Connah's Quay Low Carbon Power

Applicant's Response to Deadline 2 Submissions

Planning Inspectorate Reference: EN010166

Document Reference: EN010166/APP/9.14

Figure 13-1

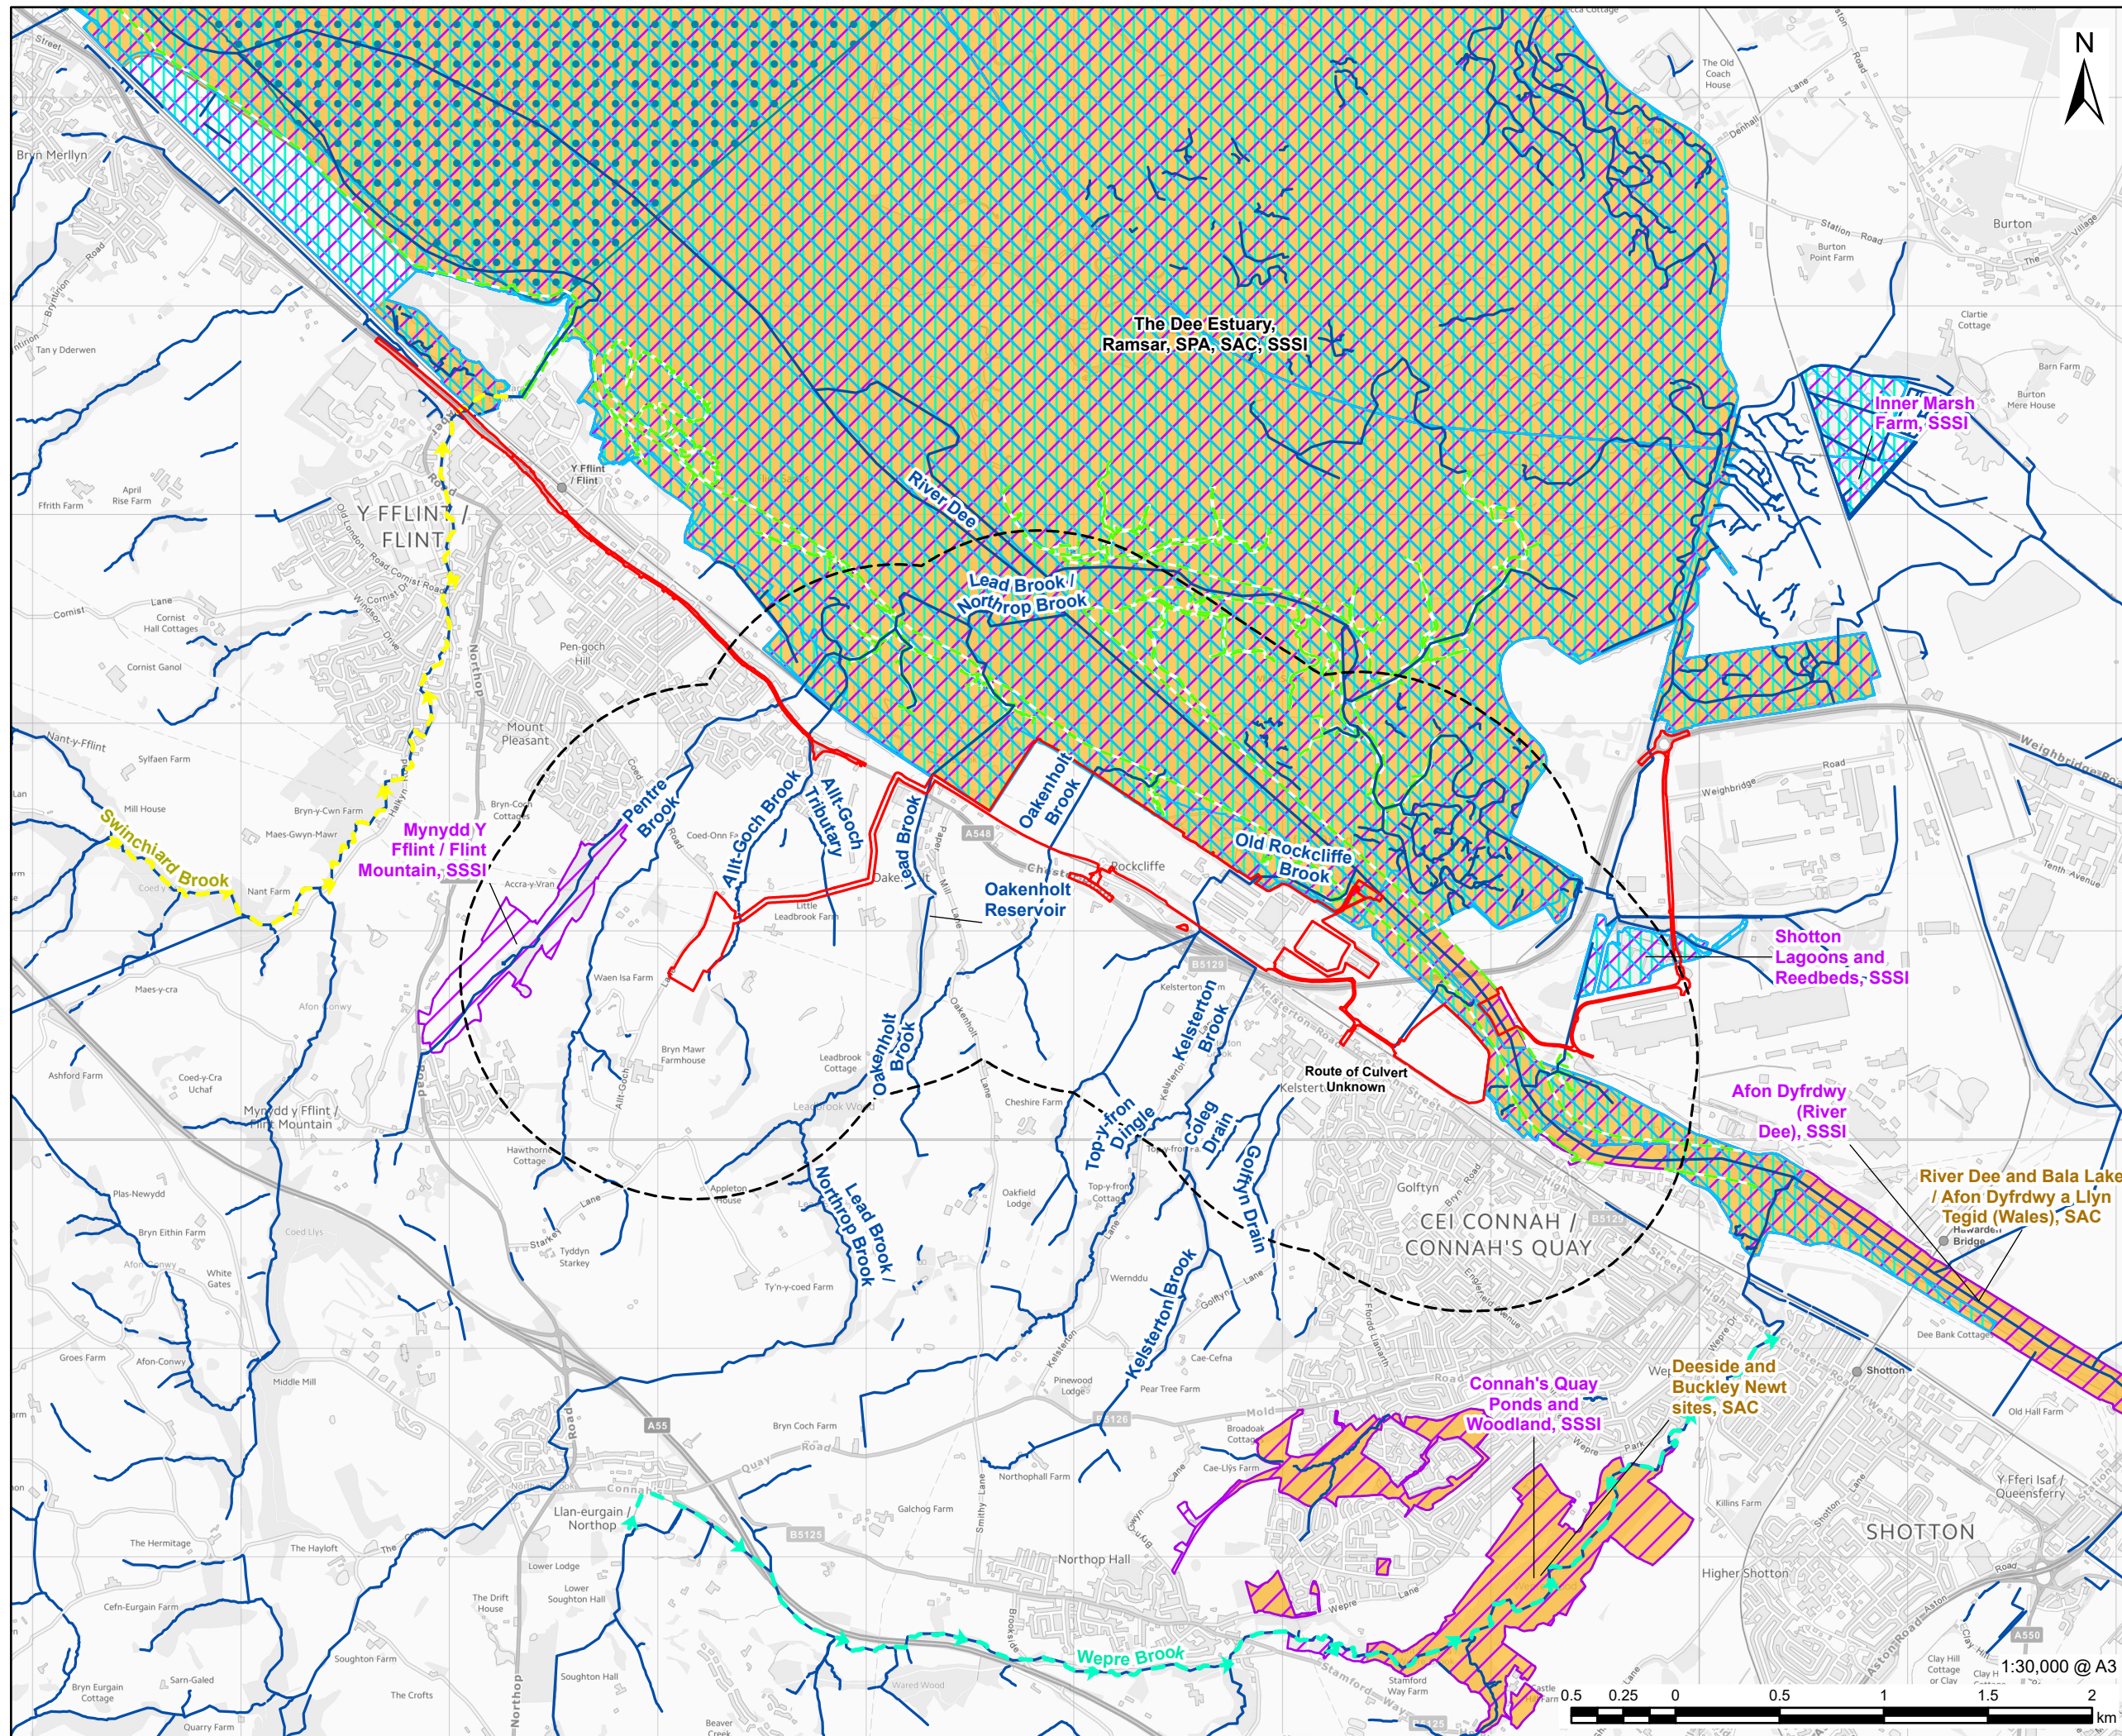
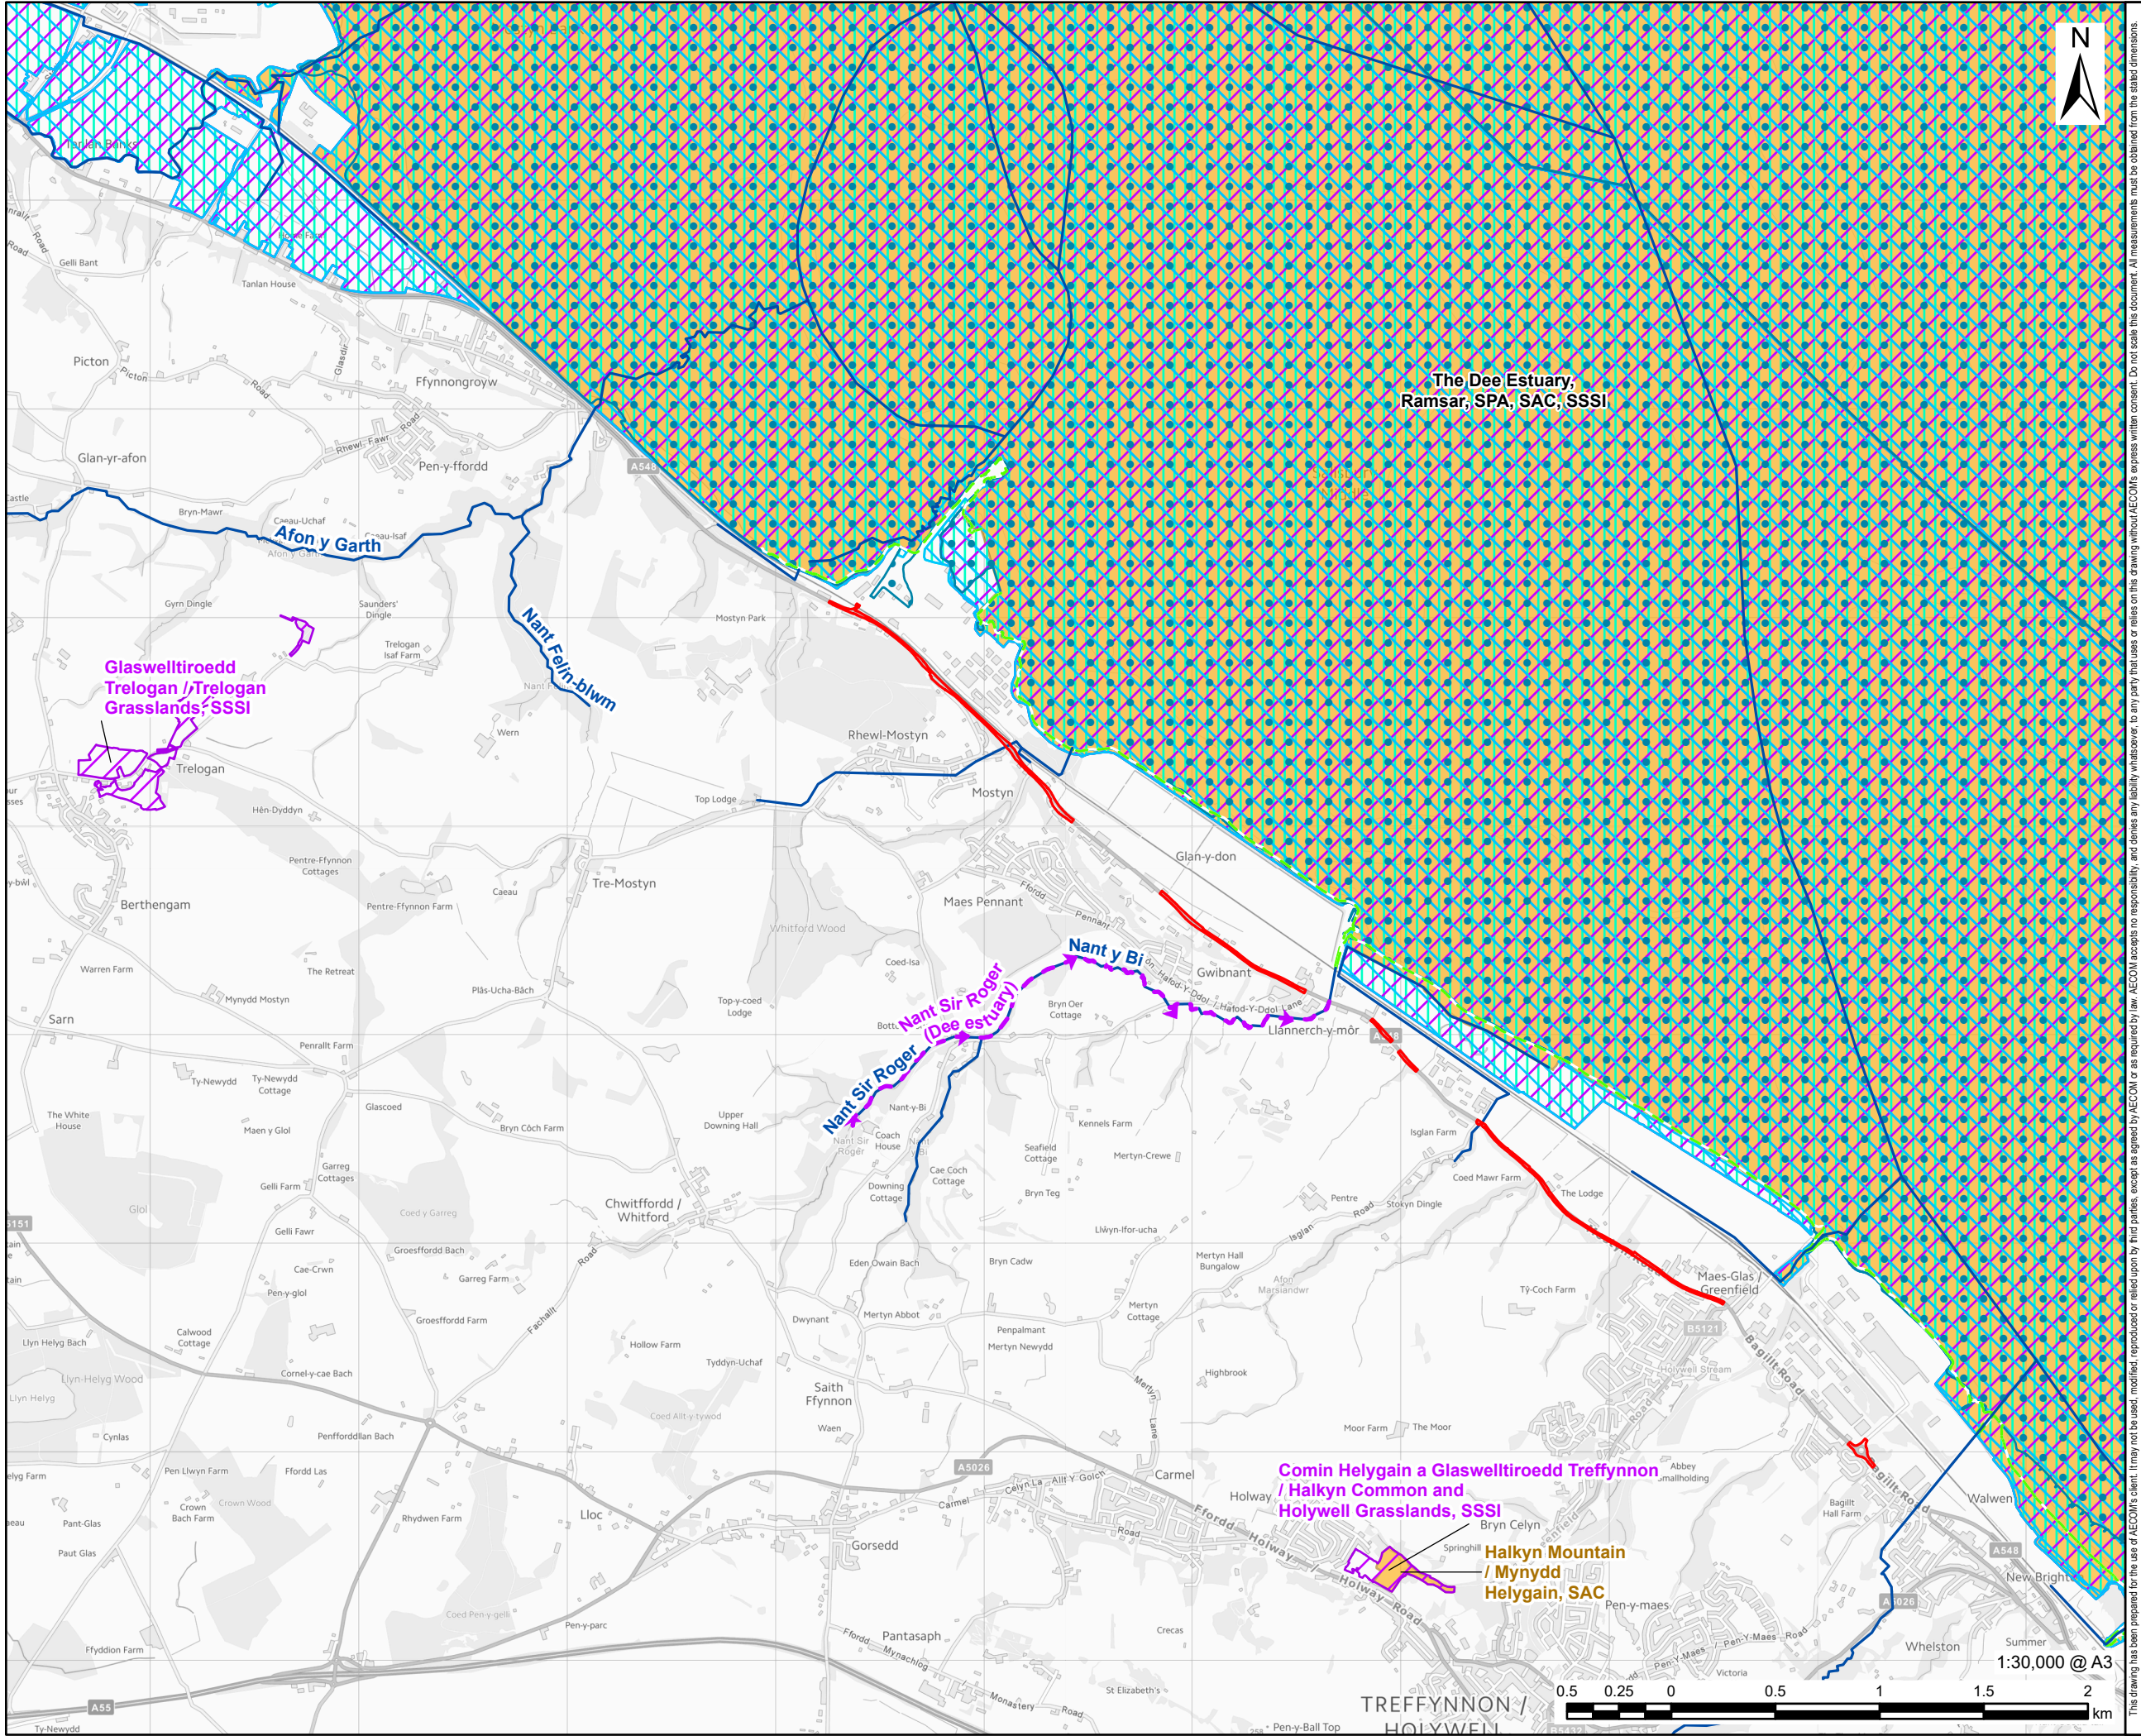
| Source Document | Reference | Source Document Issue / Theme | Applicant's Response |
|-----------------|-----------|--|--|
| | 1.11 | <p>Figure 13-1: Surface Water Features, by AECOM, dated January 2026 [REP1-015]</p> <p>We note and welcome that Figure 13-1 has been updated to include the screened-out Water Framework Directive water bodies, namely Wepre Brook and Nant Sir Roger (Dee Estuary). We therefore have no further concerns regarding this matter</p> | This is noted and welcomed by the Applicant. |
